One Earth Solar Farm

Draft Statement of Common Ground with Anglian Water

EN010159/APP/8.13

October 2025

Outline Surface Water Drainage Strategy Plans

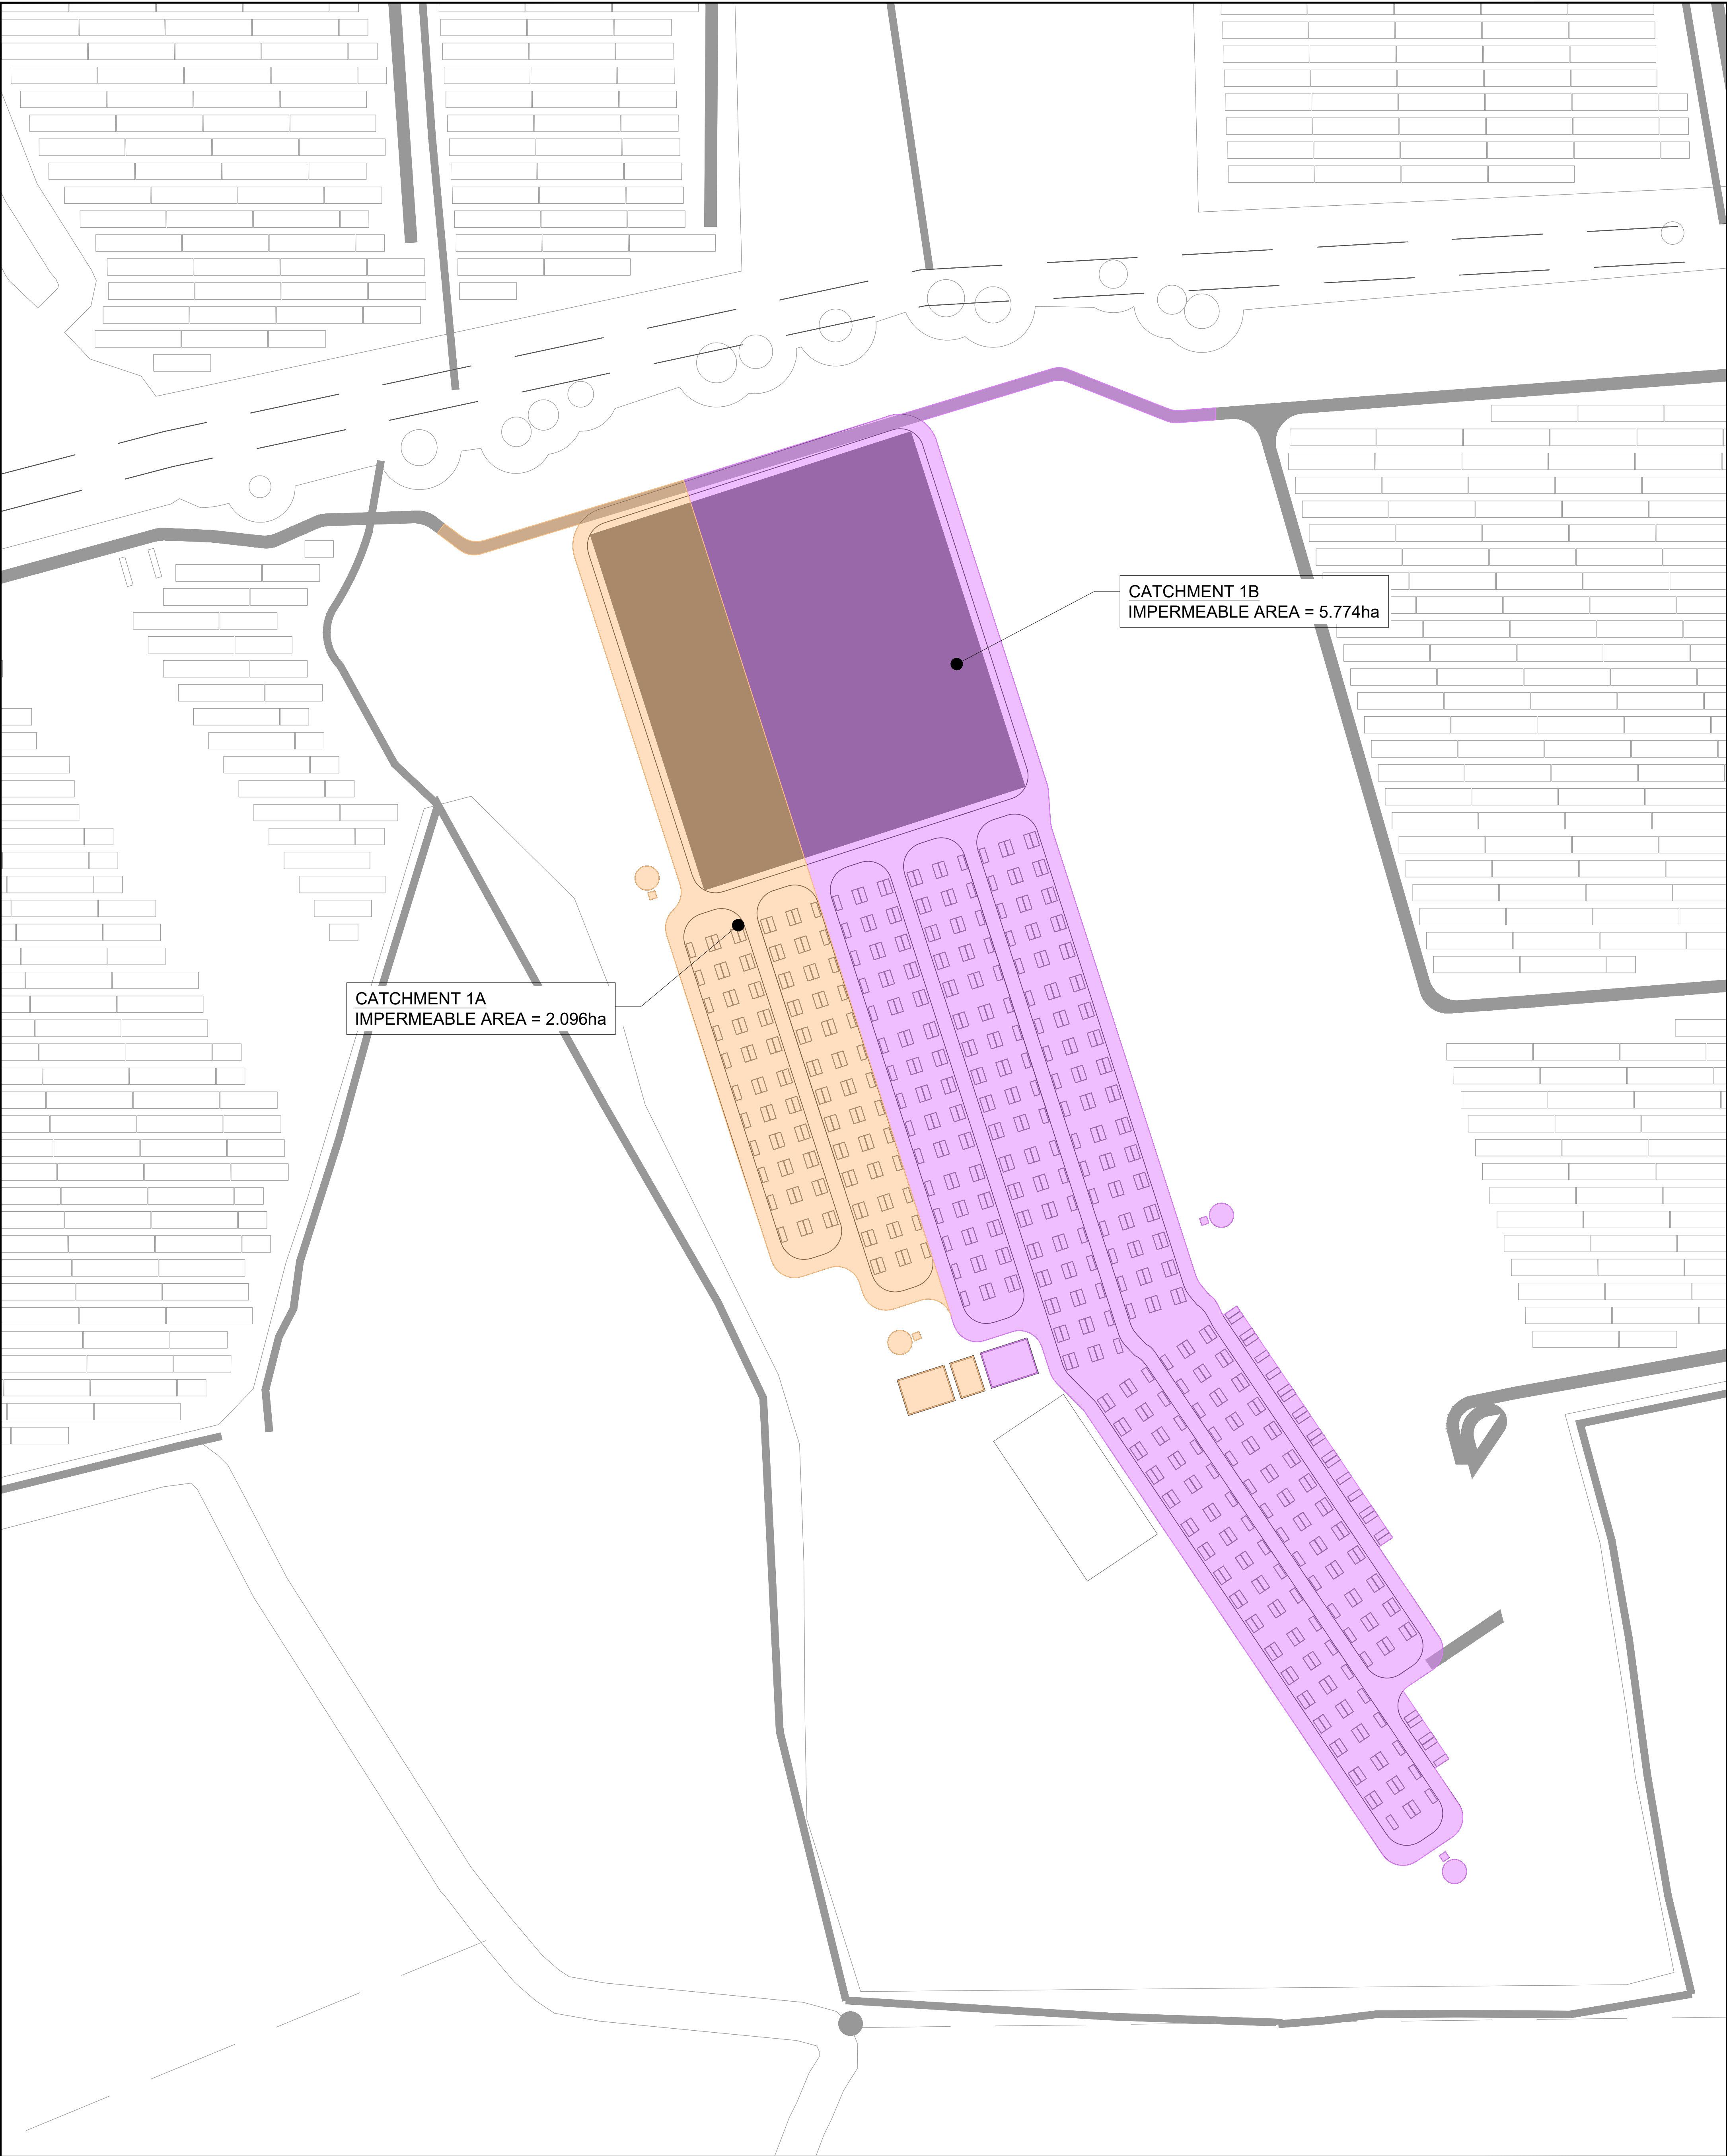
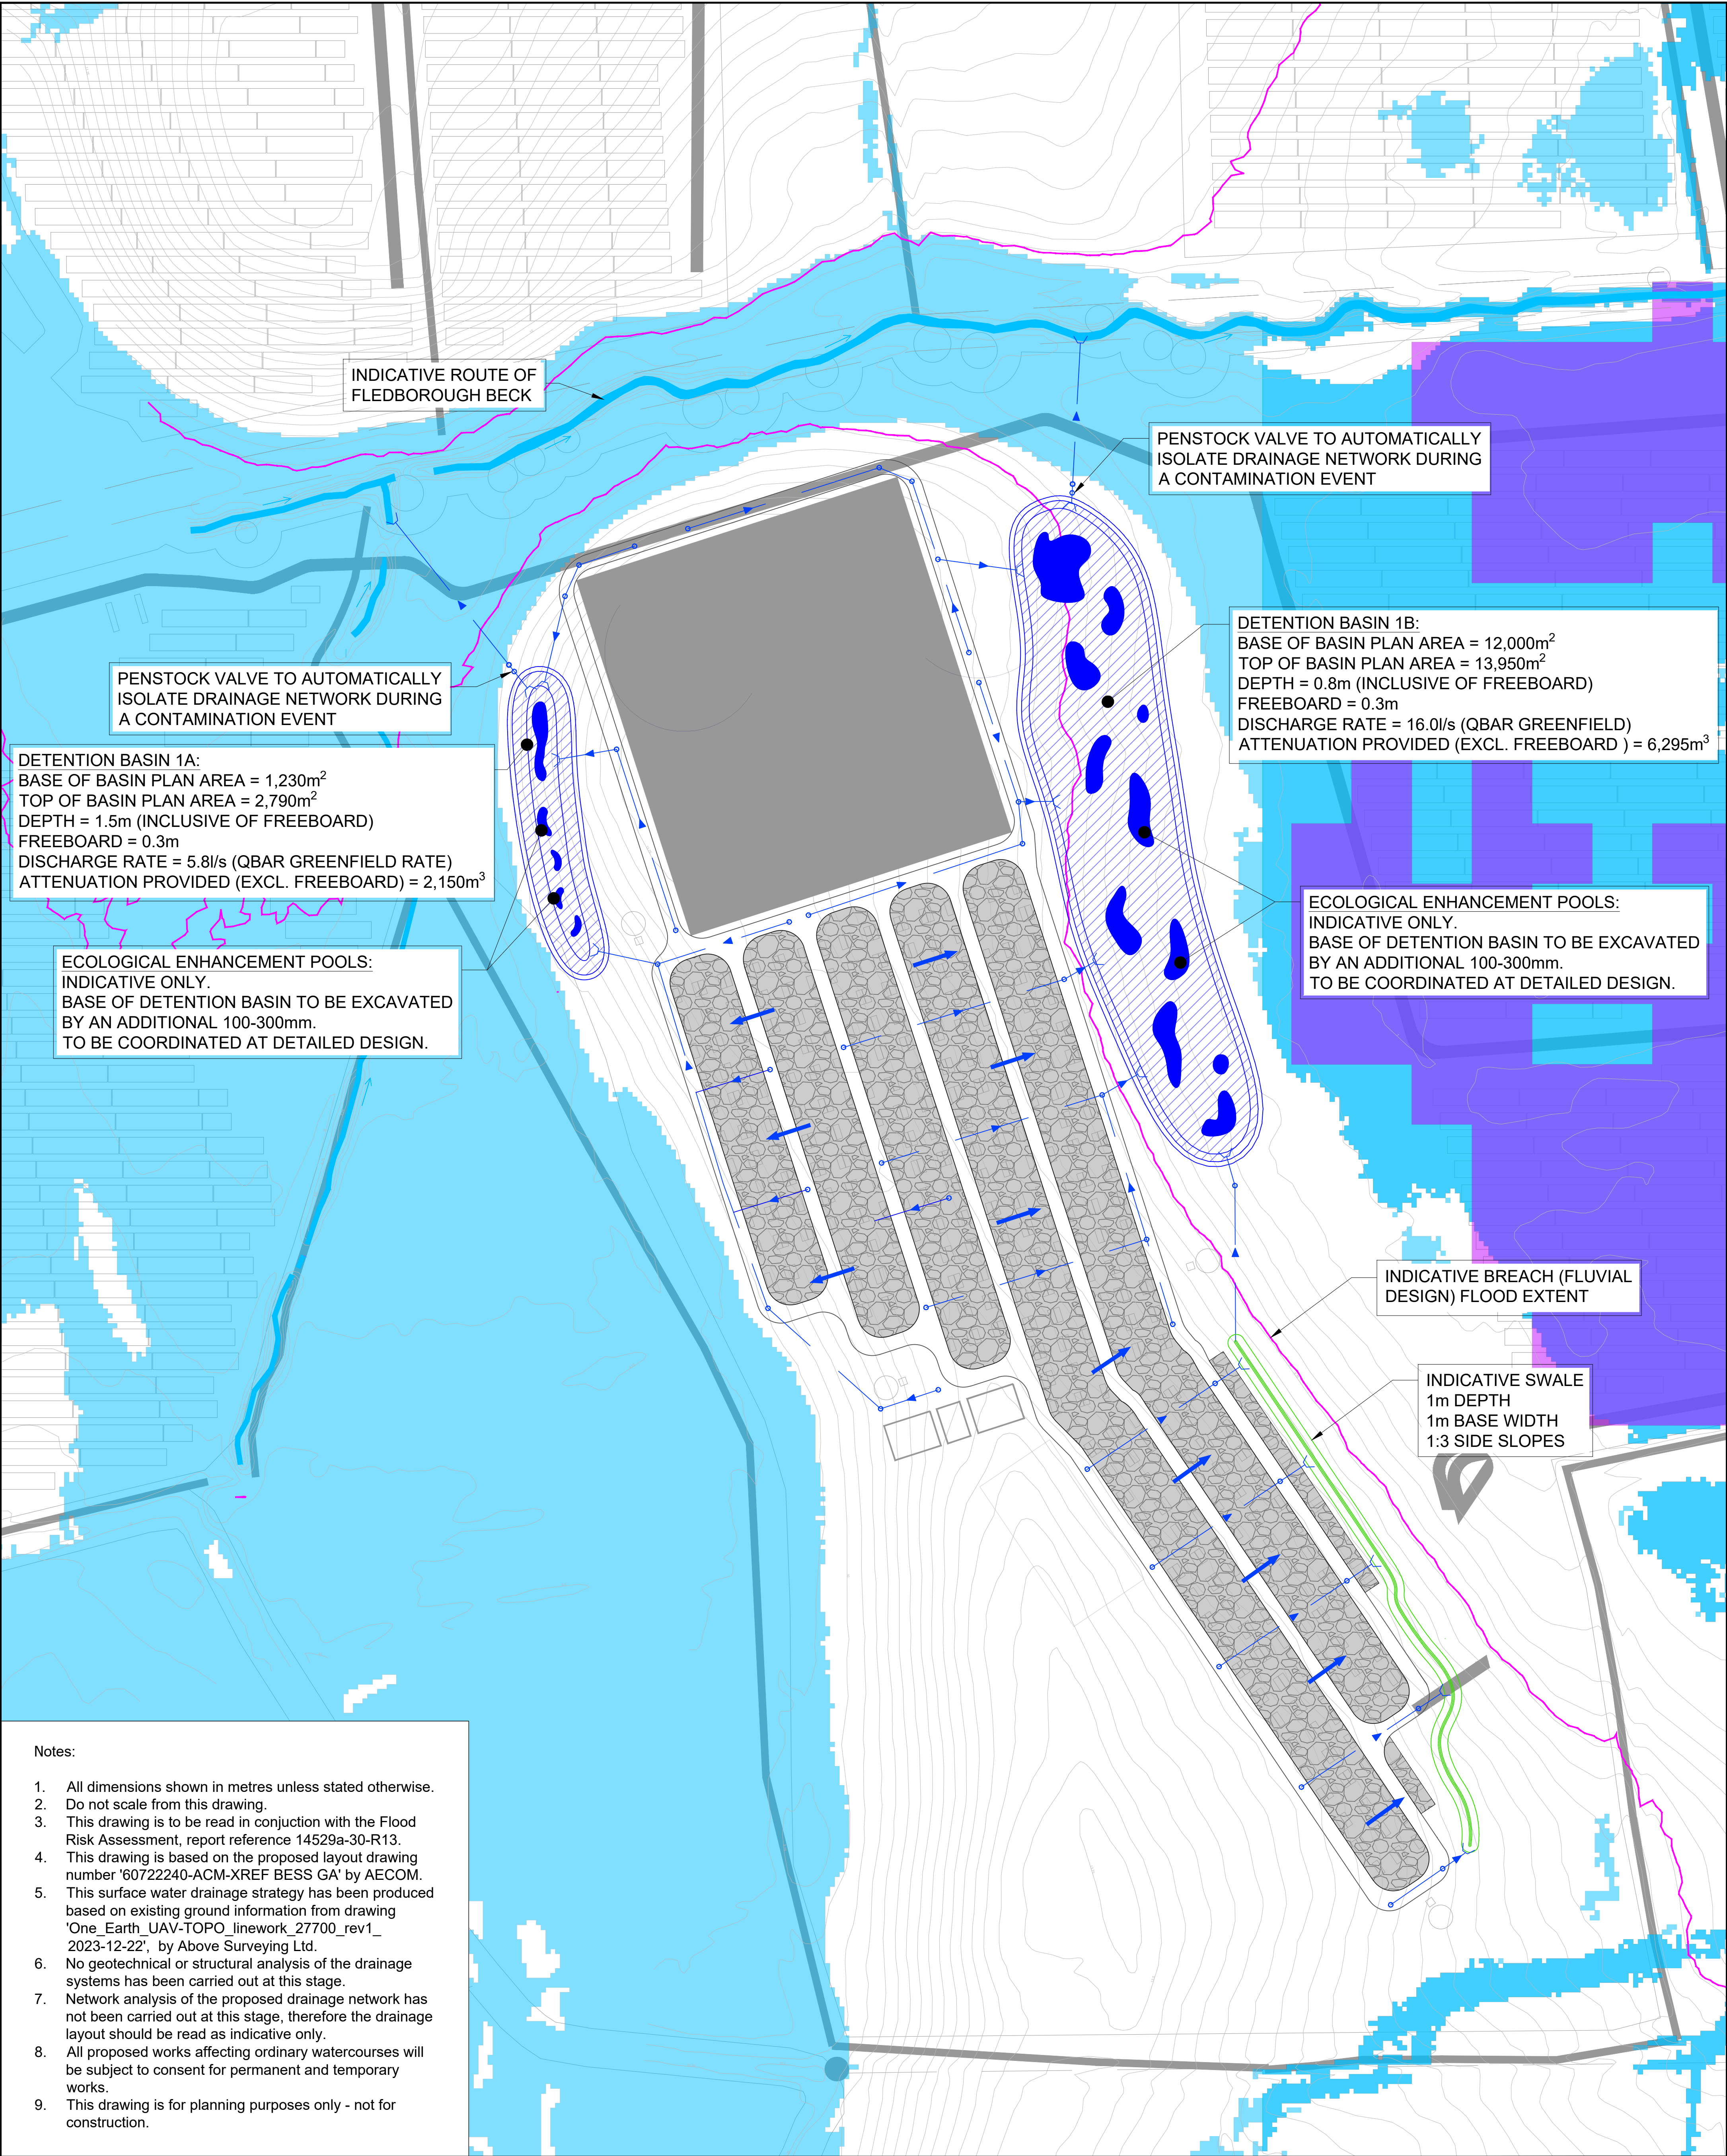
Ref.	Description of Matter	Stakeholder Comment	Applicant's Response	Status
03-03	Flooding and surface water drainage	Table 4-1 'Surface Water Drainage Hierarchy in the Flood Risk Assessment (FRA) and Outline Drainage Strategy' (APP-095) confirms it does not require the use of the public sewer network to manage additional surface water flows. As a result, we would want to ensure that there should be no right to connect powers included within the draft DCO on a temporary or permanent basis. AWS reserves its position on the need to be a consultee pre commencement Requirement on the final drainage strategy for the scheme to be submitted to the Councils, until the FRA is produced alongside the detailed design.	The Applicant can confirm that there are no current proposals to connect surface water flows to any Anglian Water public sewer and there is therefore no right to connect powers proposed for surface water.	Under Discussion
